From: Jeff Tarling
To: Helen Donaldson
CC: David Margolis-Pineo
Date: 2/25/2015 1:51 PM
Subject: Brighton Avenue Hotel Project
Attachments: Brighton Ave project.jpg

I have reviewed the landscape plan for the proposed hotel project on Brighton Avenue and offer the following review comments, recommendations for approval:

Sheet No.: **L1.1**

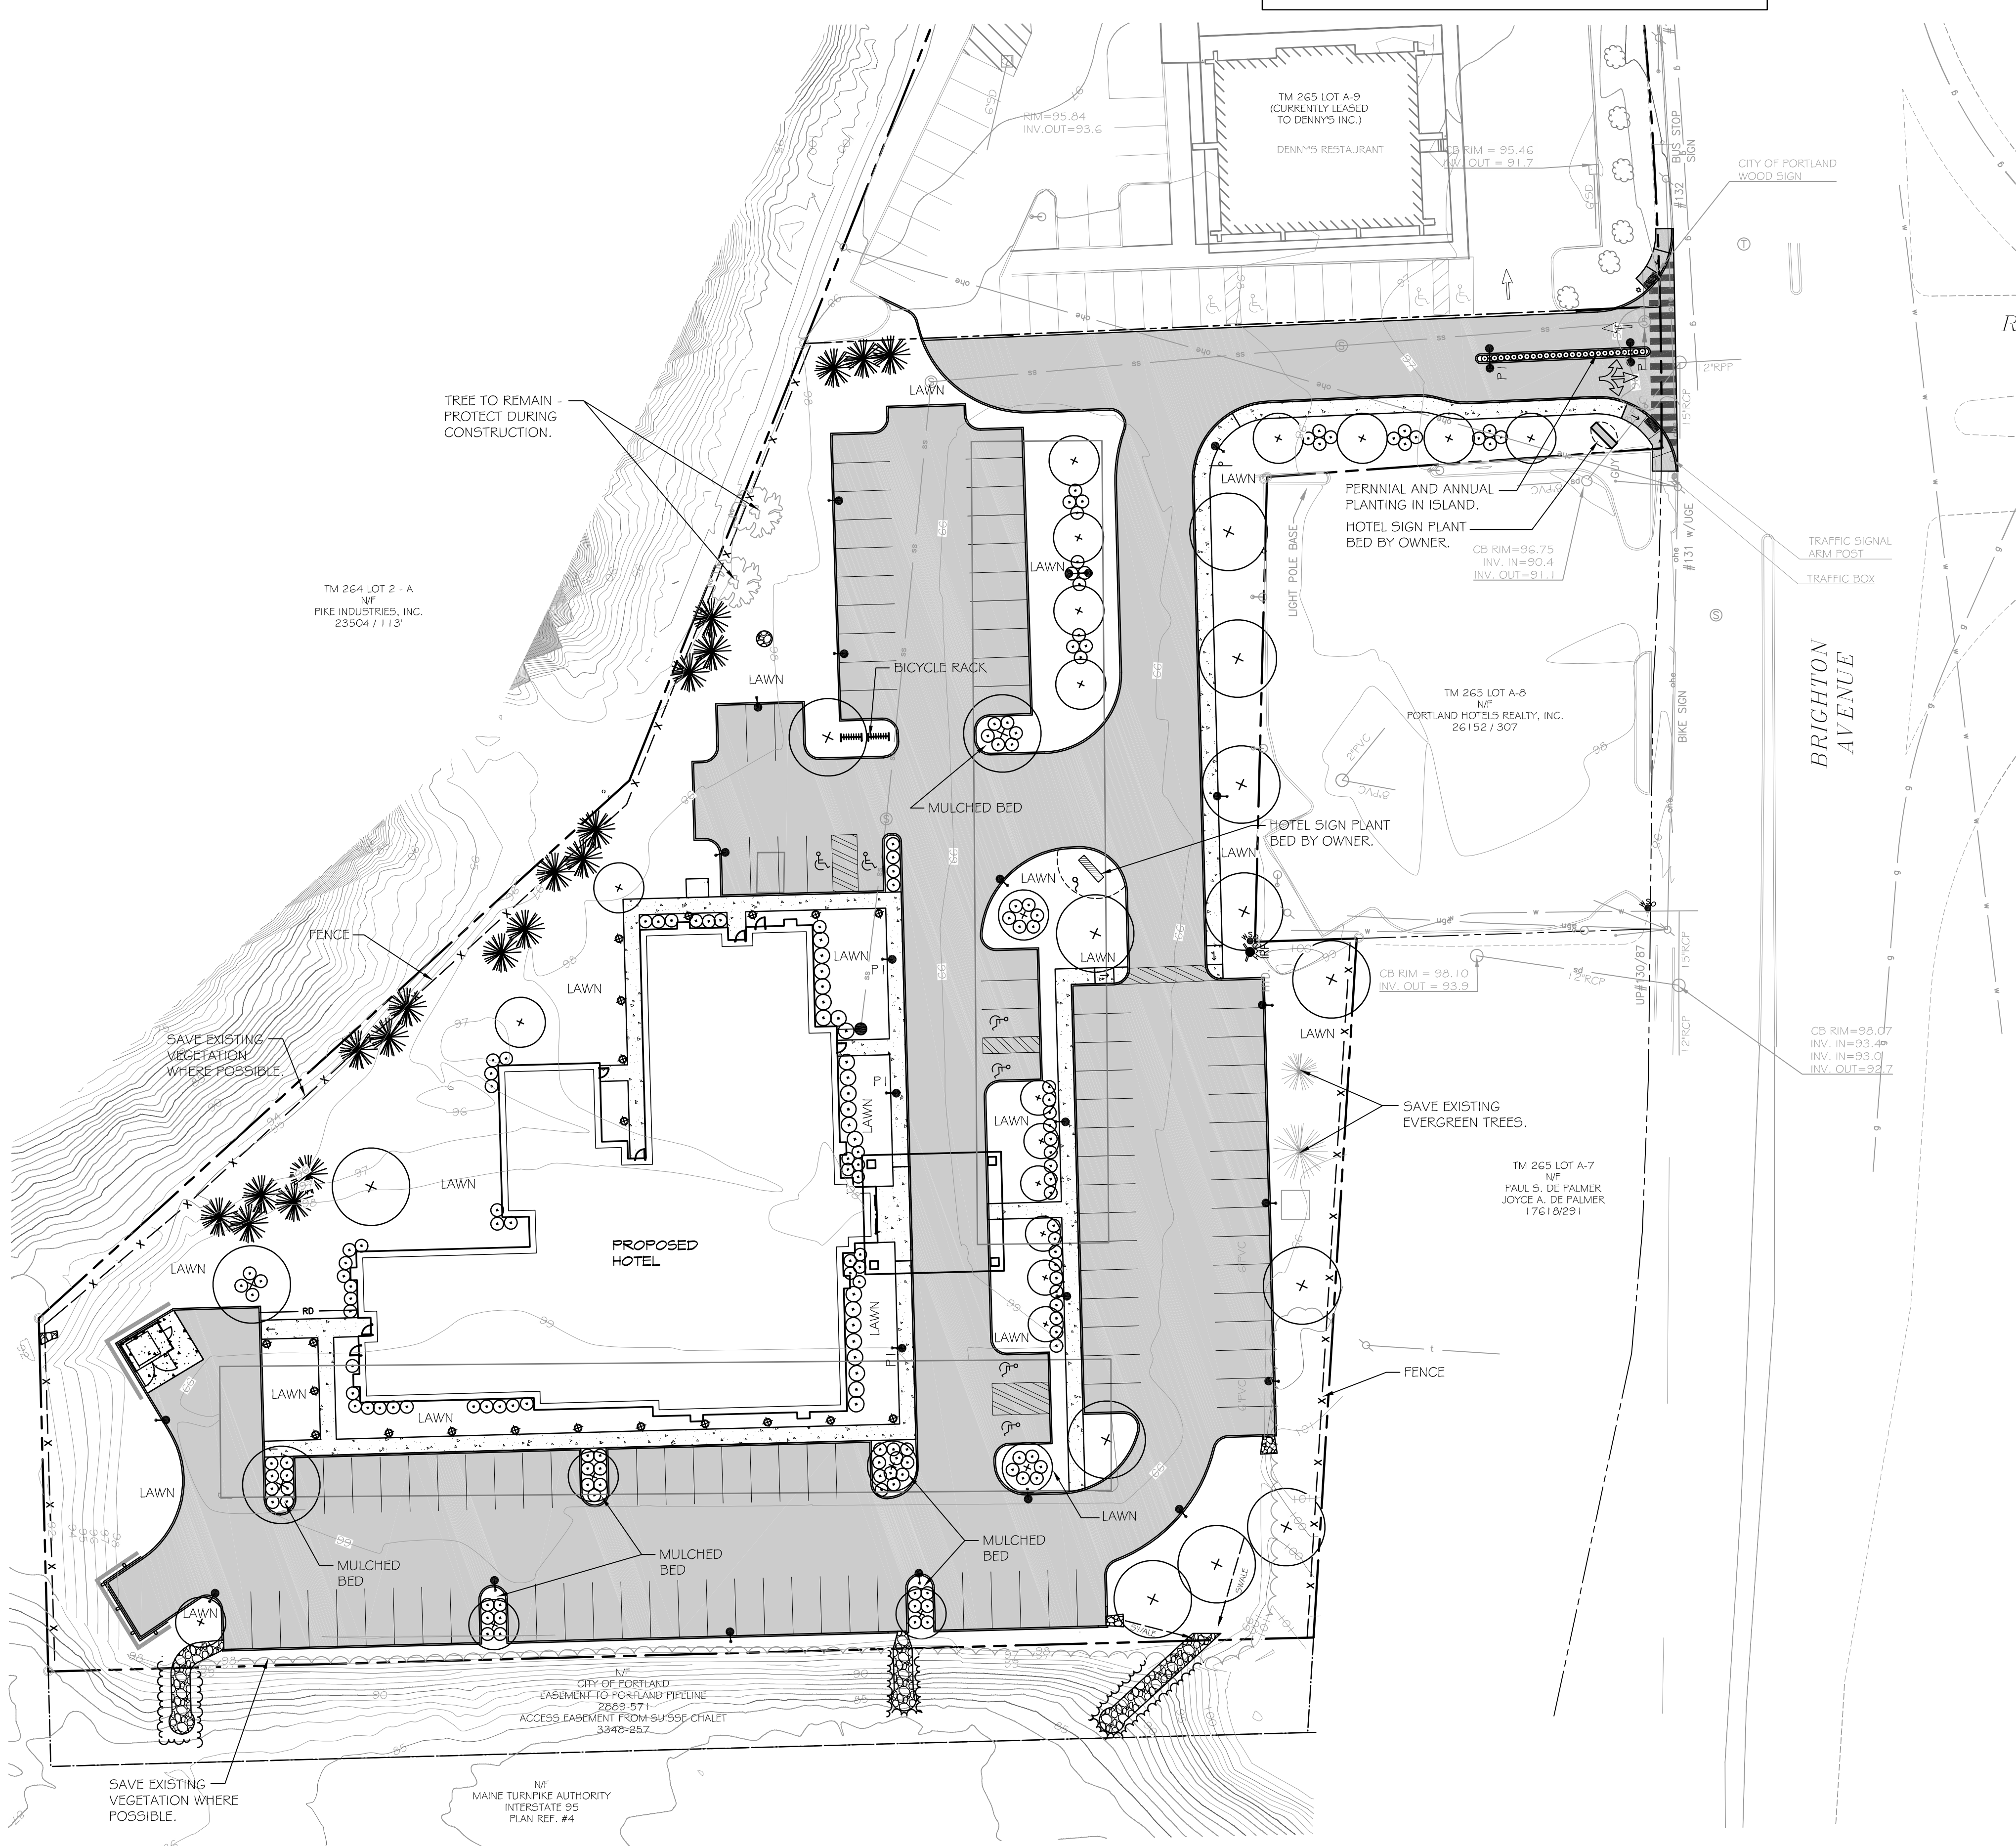
1) Plant List Key & landscape plan identification - A list of actual plant types and locations would be a requirement for approval. With the exception of 'Ash' varieties which we strongly discourage due to eminent treat of 'Emerald Ash Borer' decline, the plant types suggestion are acceptable. It is important to have a landscape plan with key that shows the actual tree and plant types to a specific location on the plan.

2) Parking lot tree & landscape standards - all parking lot locations would need to meet city standards pertaining to the number of trees / shrubs to vehicle spaces. The top left parking lot does not appear to meet the standard on the Pike side of the lot (3 additional trees suggested) and the main parking lot does not appear to meet the standard along the Brighton Avenue side (and the parking lot along the Maine Turnpike does not show adequate tree spacing, likely 6 more shade trees are needed in this location.

3) Entrance island near proposed hotel sign shows one tree and six shrubs along with 'plant bed by owner', this area is an important landscape feature or element to help incoming and exiting traffic with wayfinding. Recommendations would be to enhance this area with landscape features that could include adding a slight mound or contour, additional landscape planting to better incorporate the proposed landscape bed with what is shown on the plan.

4) Brighton Avenue / Maine Turnpike corner - "Tree Save" / Buffer needed, unknown how much of the existing vegetation will be saved with the installation of the swales in this area. If removed, the area will need more than the proposed three trees to buffer this area. Five to seven evergreens would likely be needed to match the existing vegetated area.
